25th June 2021

Angmering Parish Council
Angmering Parish Council
The Square
Angmering
BN16 4EA

Application No: A/102/21/HH
Site Address: Milner Cottage The Thatchway Angmering BN16 4HJ
Description of works: Erection of single storey side extension following the demolition of existing conservatory

Roof Plan (1:100)

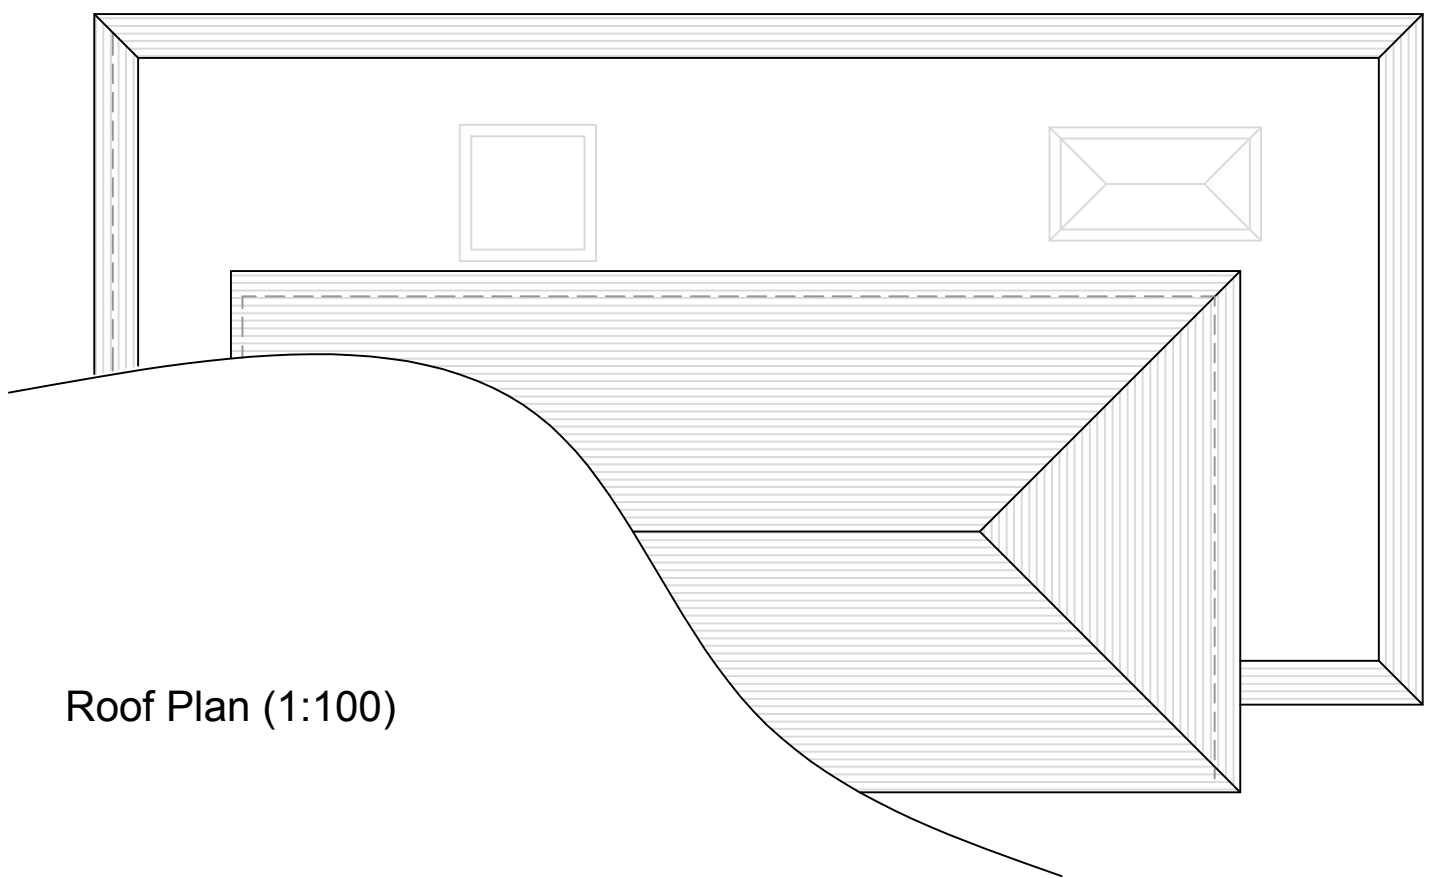
We have no objection to this extension provided consideration is paid to any dark night skies policy with regard to the roof windows
